2280.08-DRAWING REVISION SCHEDULE

MOD18 - A0002 - SHADOW DIAGRAM 21 JUNE

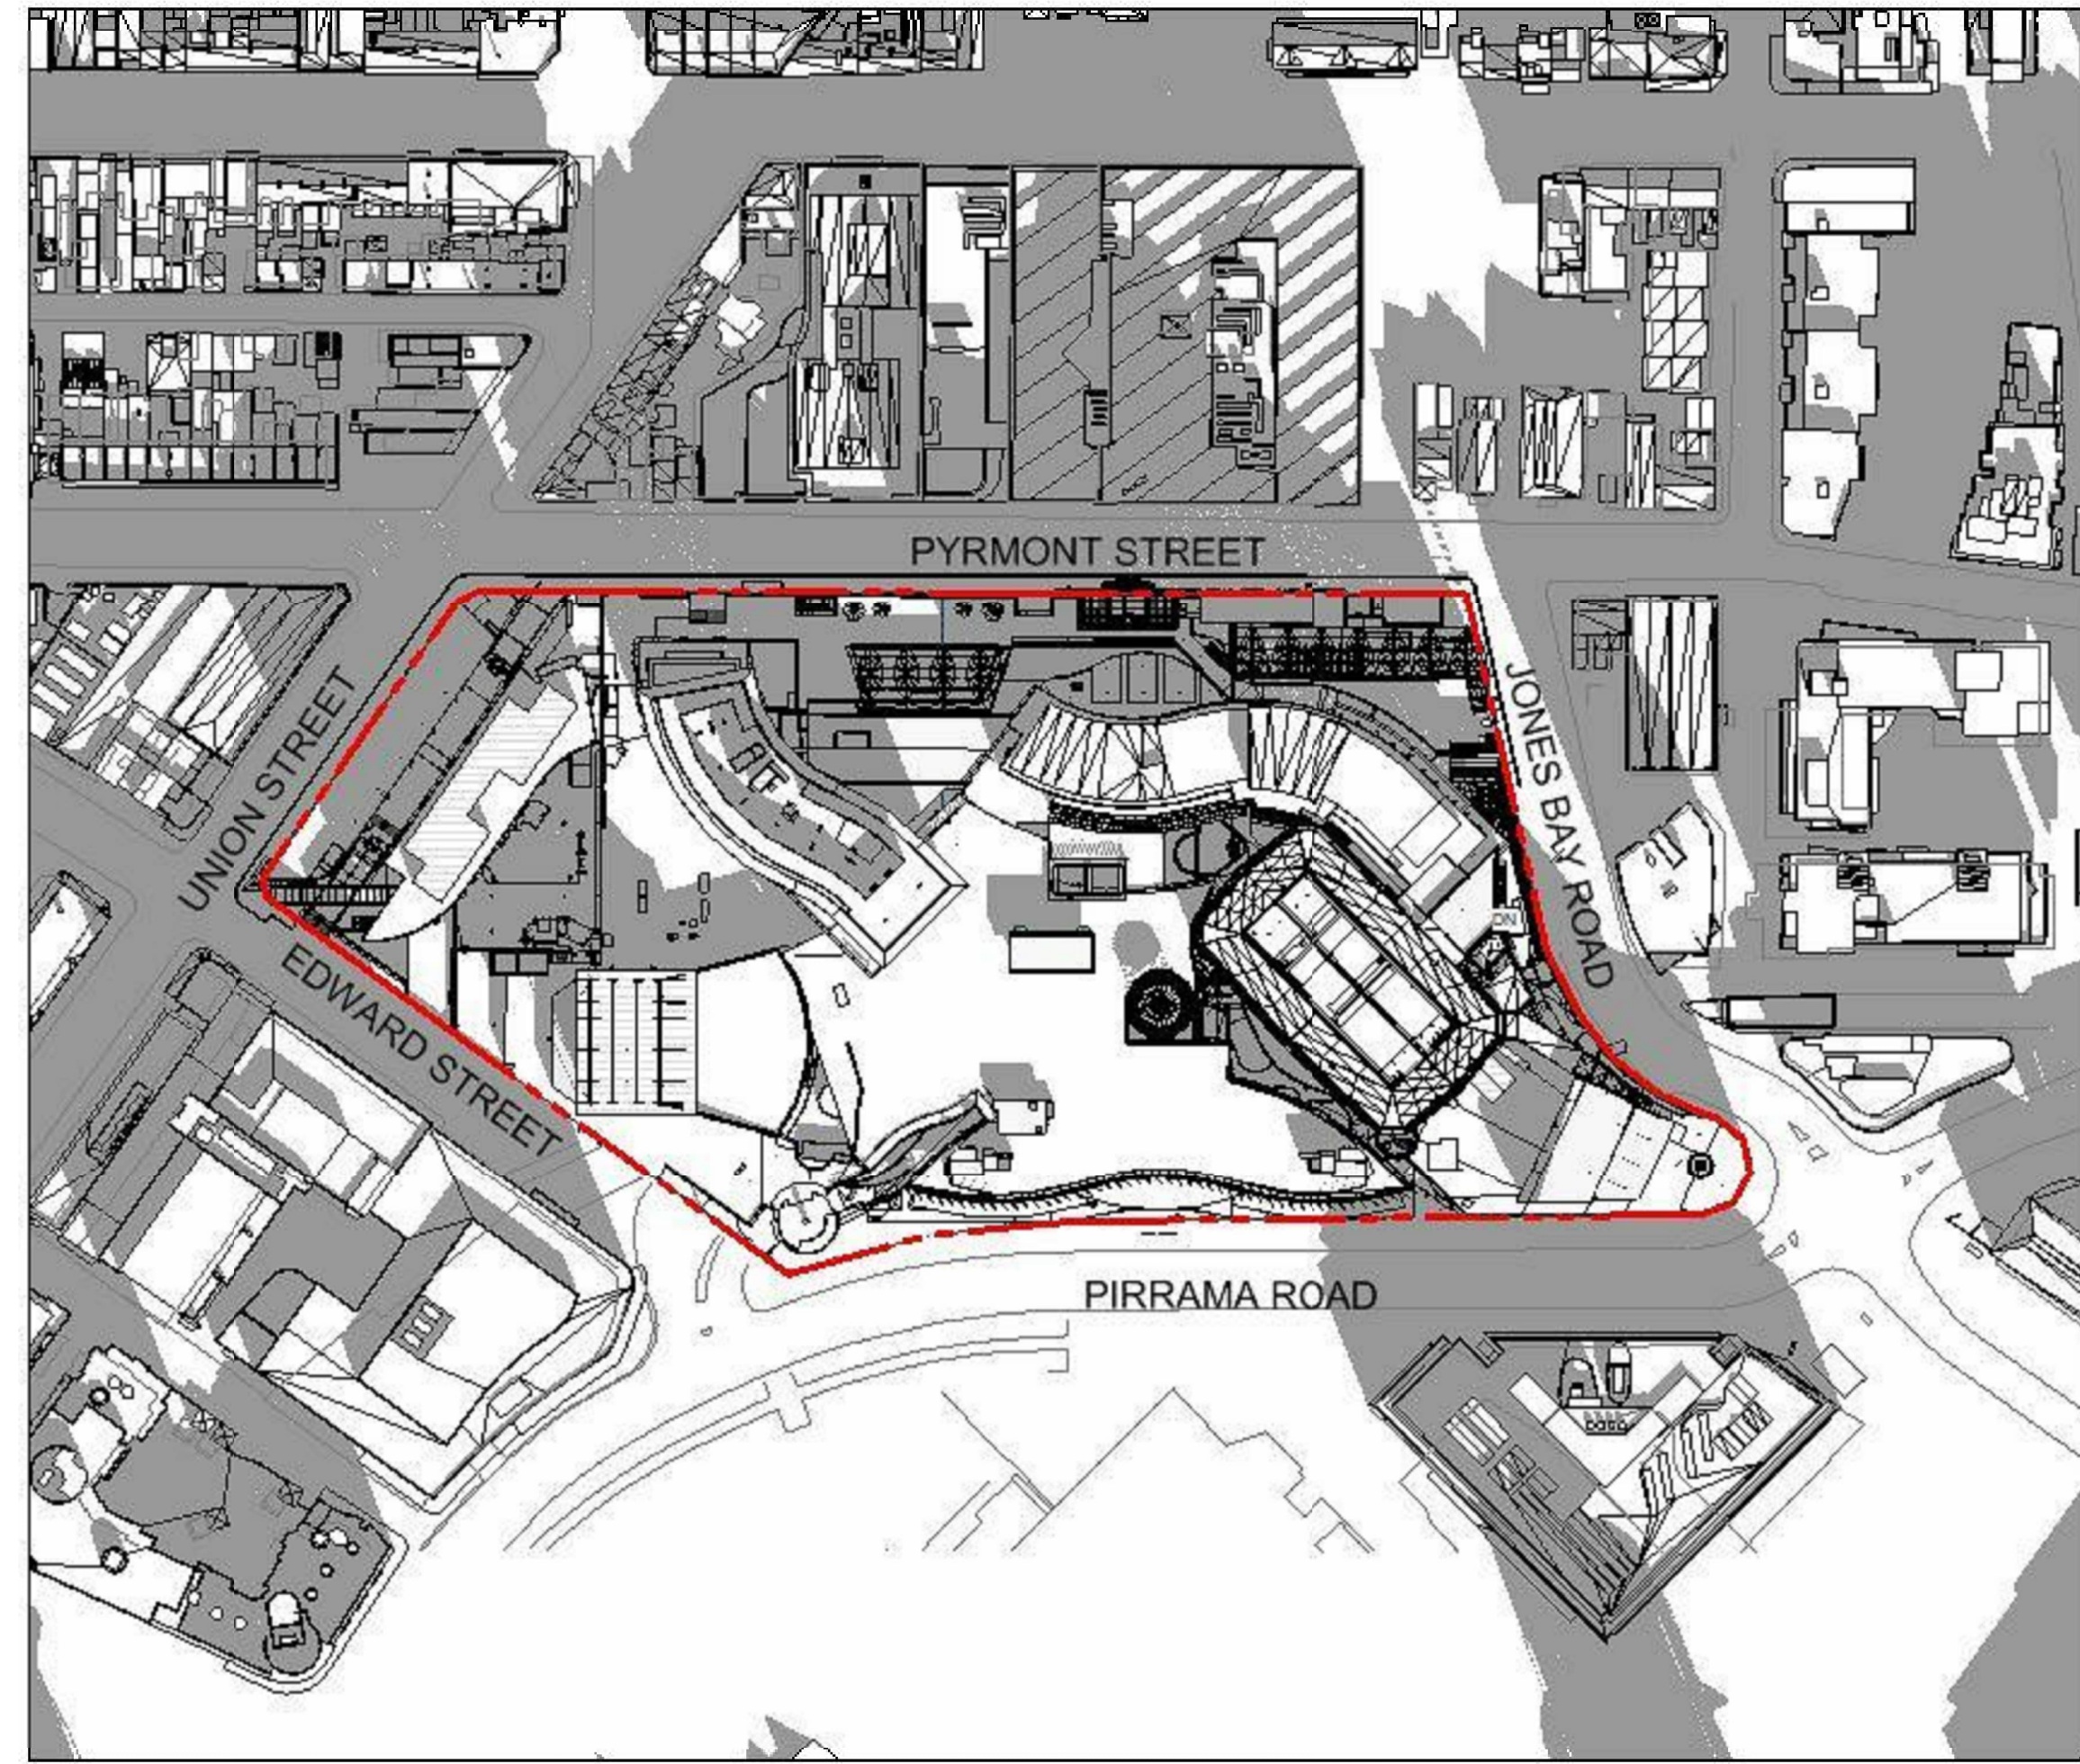
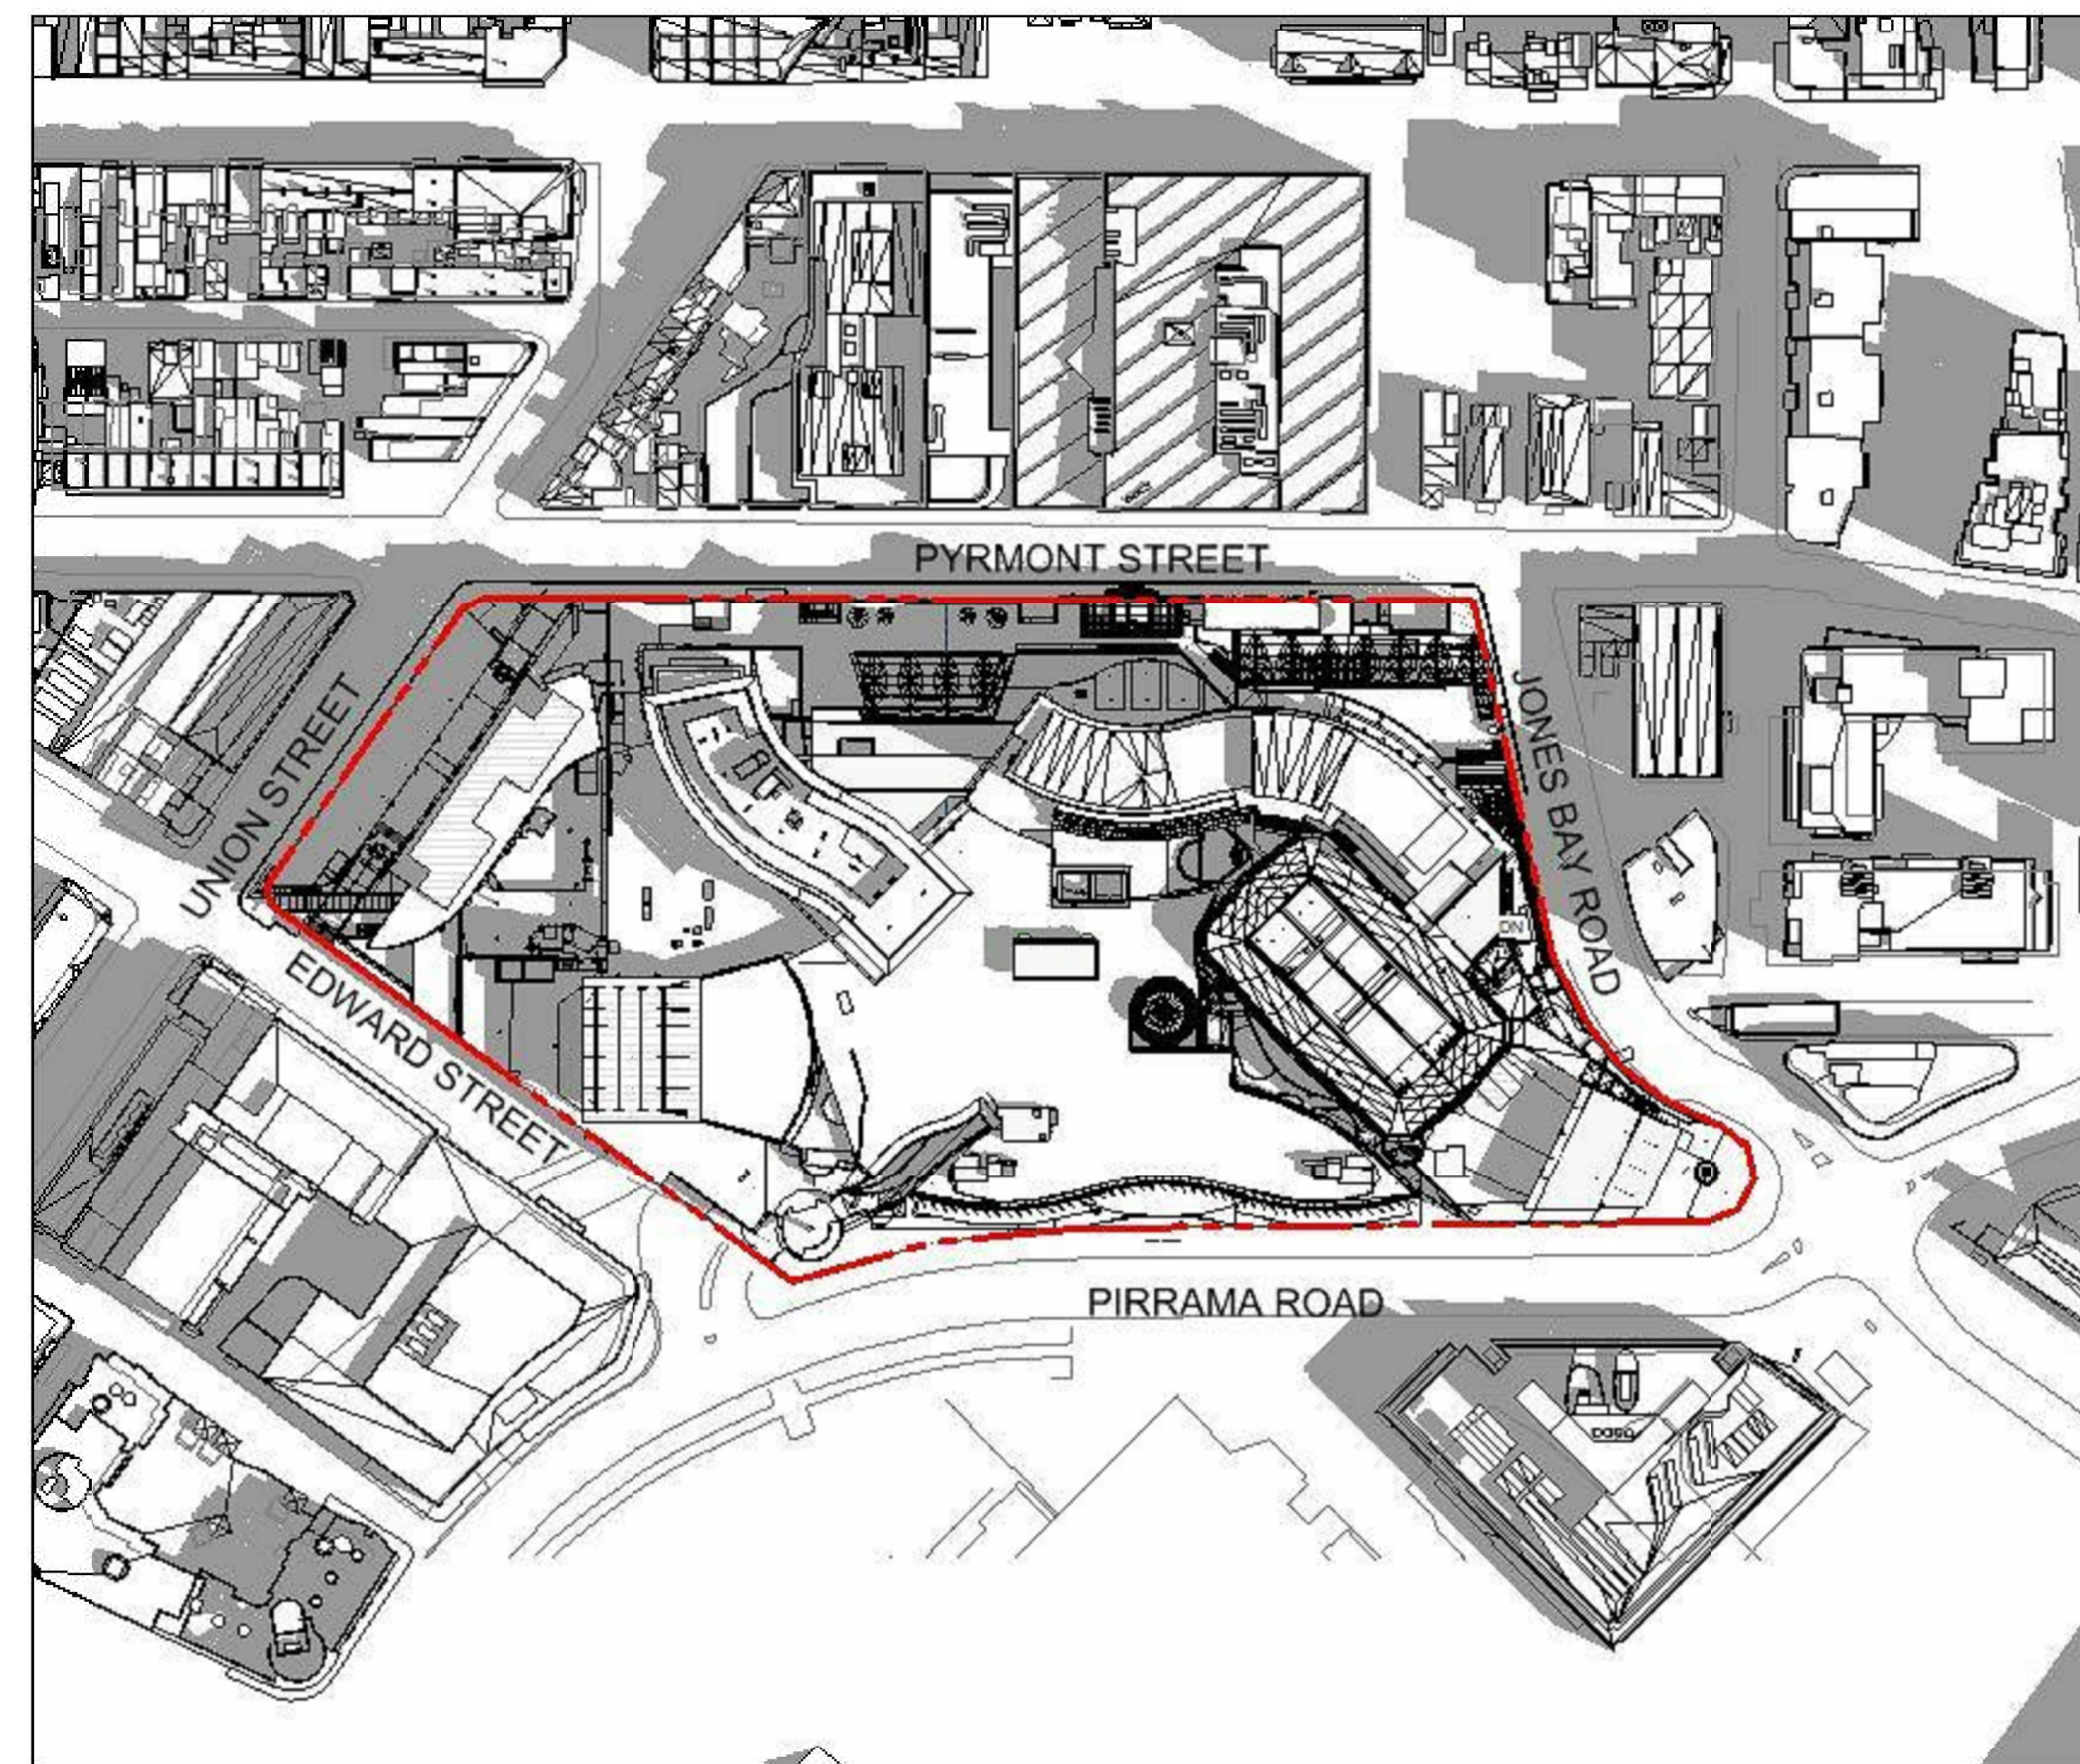
1. Footprint of fly tower reduced to suit comments from DPE and City of Sydney.
2. 4 level extension over existing dressing rooms reduced to 3 levels over existing dressing rooms. Aluminium clad screen extending from 4 level extension and on front of existing plant room omitted.
3. Double height plant room extension omitted from scope.
